## Appeal Decision

**Appeal Ref: APP/T2350/W/24/3355513**

**Knott Farm, Chipping Road, Thornley, Lancashire PR3 2TB**

- The appeal is made under section 78 of the Town and Country Planning Act 1990 (as amended) against a failure to give notice within the prescribed period of a decision on an application for planning permission.
- The appeal is made by Mrs Ena Tansley against Ribble Valley Borough Council.
- The application Ref is 3/2023/0367.
- The development proposed is change of use from former agricultural barn building to single dwelling house Class C3(a) following part demolition of recent steel frame extension to north end and erection of replacement pitched roof to north end.

Project	THORNLEY - KNOTT FARM, CHIPPING ROAD PR3 2TB		
Drawing Title	KNOTT FARM BARN PROPOSED CONVERSION TO SINGLE DWELLING PROPOSED PLANS AND ELEVATIONS		
Scale	Date	Drawing No.	Rev.
As Shown	13/ 07/ 20	3526-004	G 6/ 04/ 23

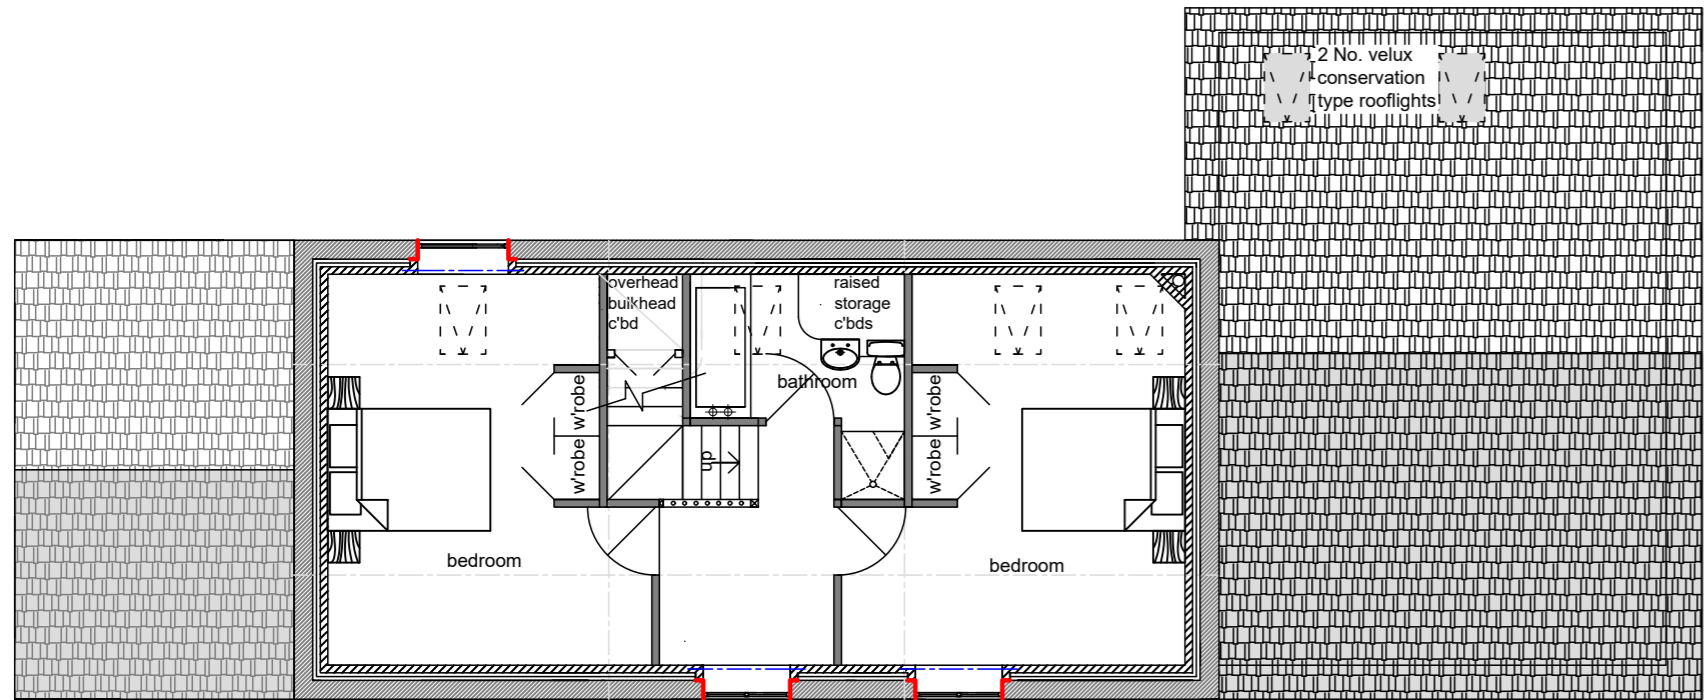
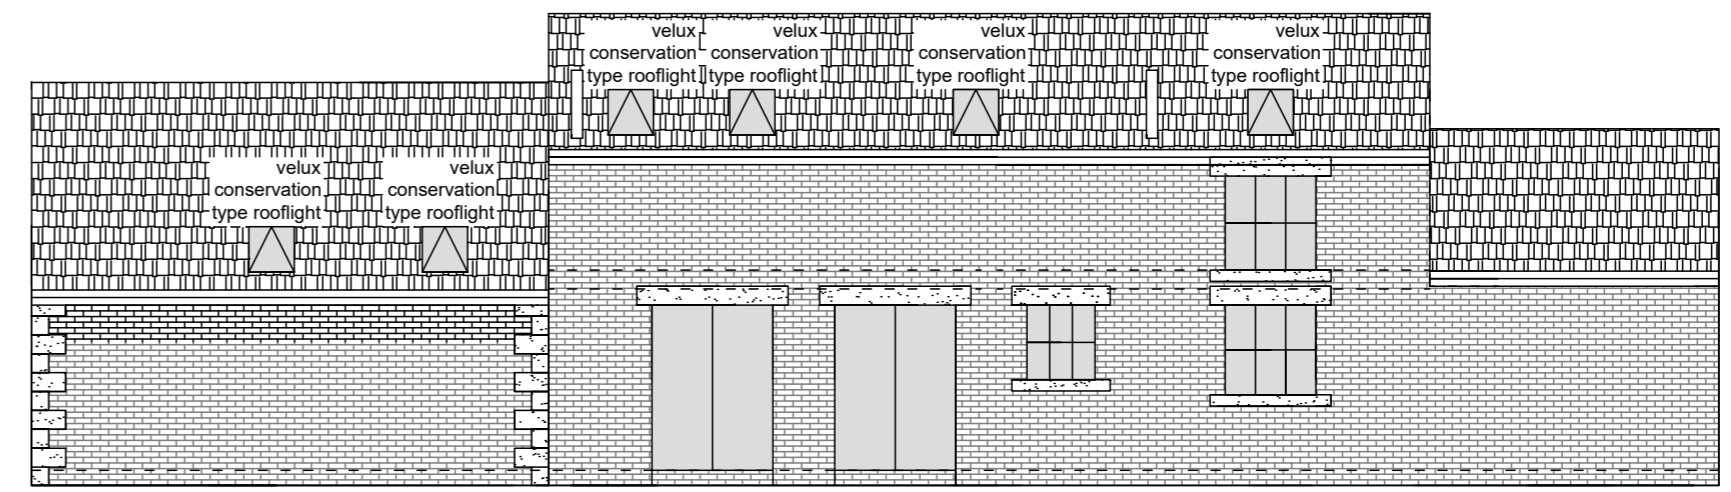
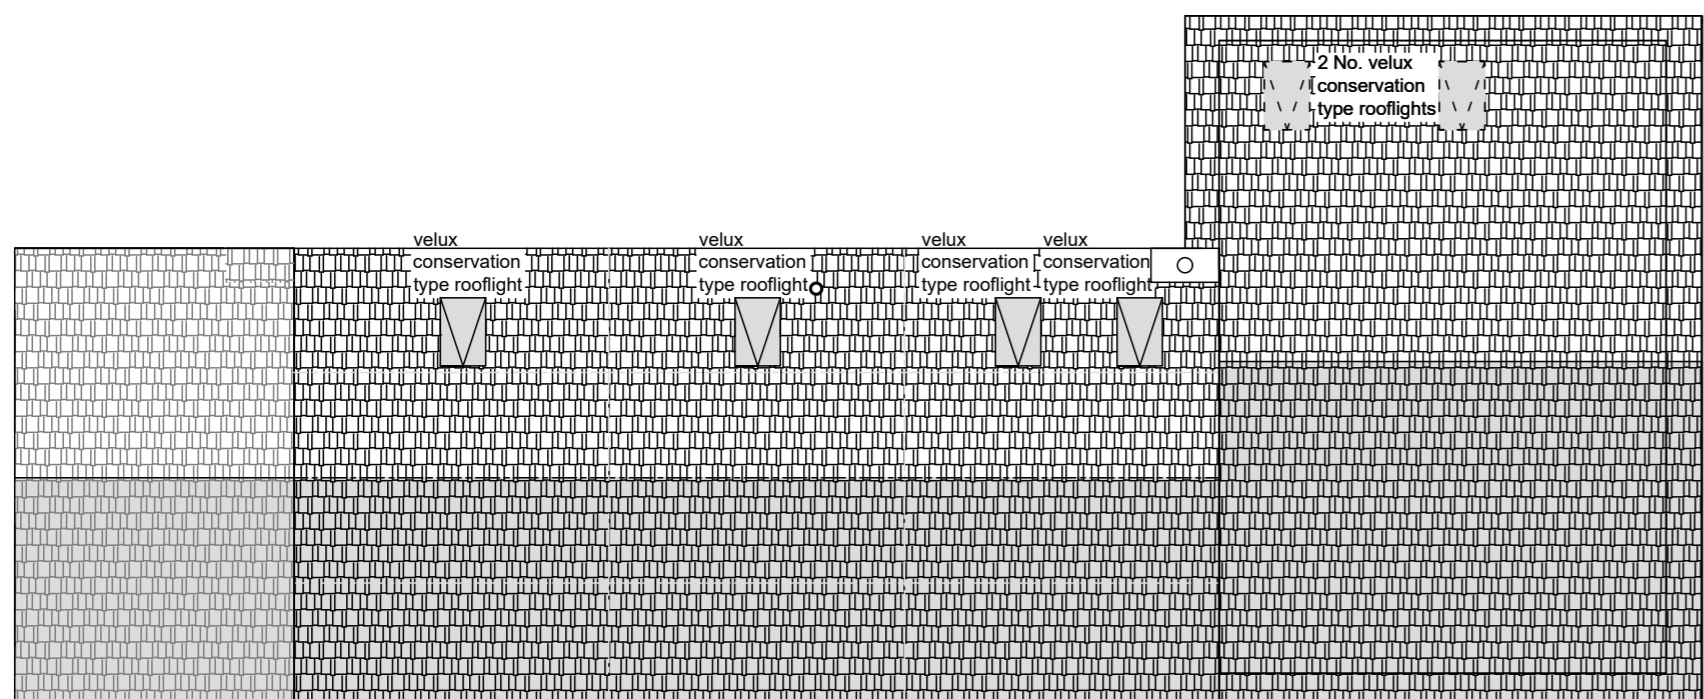
5. The steel frame extension would be replaced with a single storey extension (the rebuilt extension) which would be finished in brick with a dual pitch slate roof. This would have domestic doors, including a tri-fold door, and windows to all elevations. The steel frame structure is of no architectural or historic merit, but it is typical and illustrative of the evolution of rural agricultural buildings. In contrast, while its external materials would match the 2-storey part, the rebuilt extension would be a domestic feature such as would not look out of place in a more urban setting.

6. The number and general arrangement of openings in the principal elevation would remain largely the same as existing. However, the upper parts of the doors would be glazed and there would be 2 new domestic windows instead of a cart door opening in the rebuilt extension. Consequently, there would be a significant increase in the number of glazed openings, from 3 to 9, the majority of which would be conspicuously linearly arranged at ground floor level. The part glazed/ part boarded doorway openings, without a boarded upper half, would not reflect stable doors. Moreover, the glazing of the first floor opening, with removal of the existing wooden door, would erode the appearance of the former hay loft opening.

7. The rear elevation is blank, except for 3 rooflights close to the 2-storey ridge. The south west elevations of the single storey extensions to either end would remain blank, but the 2-storey rear elevation would feature 2 bi-fold glazed doors and a new window at ground floor level, together with 2 new first floor windows. The overtly domestic scale, number, design and regular arrangement of new openings would not reflect or respect the historic functional agricultural use of the building.

8. The proposal would not require substantial rebuilding or extension. Even so, the new openings to the rear elevation, and bi-fold and tri-fold doors, would be a conspicuous visual change resulting in the appearance of an overtly domestic and more contemporary building. The cumulative changes to openings and fenestration to all elevations and the generic rebuilt extension would significantly domesticate the former barn and erode its historic agricultural and rural vernacular appearance. The proposal would diminish the local distinctiveness and sense of place of the farmstead group and the Forest of Bowland National Landscape.

9. The appeal site is in a relatively remote location, but the footpath passes through the yard in front of the appeal building. Therefore, the proposal would be readily visible. I accept that, by virtue of the building's orientation, the domestic rear elevation might not be publicly visible at close range. Even so, the extensively glazed domestic openings would be likely to catch the light and emit significant light spill such as would be conspicuous from further afield.

11. The residential conversion would require the creation of new openings for doorways and to allow natural light into habitable rooms. However, there is little robust justification for the size and arrangement of rear fenestration, including the extent of glazed doorways opening onto the patio area, or the number of new doors or windows more widely. I acknowledge that the proposals have been amended since the earlier withdrawn scheme and during the processing of the application. Even so, there is little compelling evidence that there are no alternative designs such as could result in similar benefits without the harm that I found.
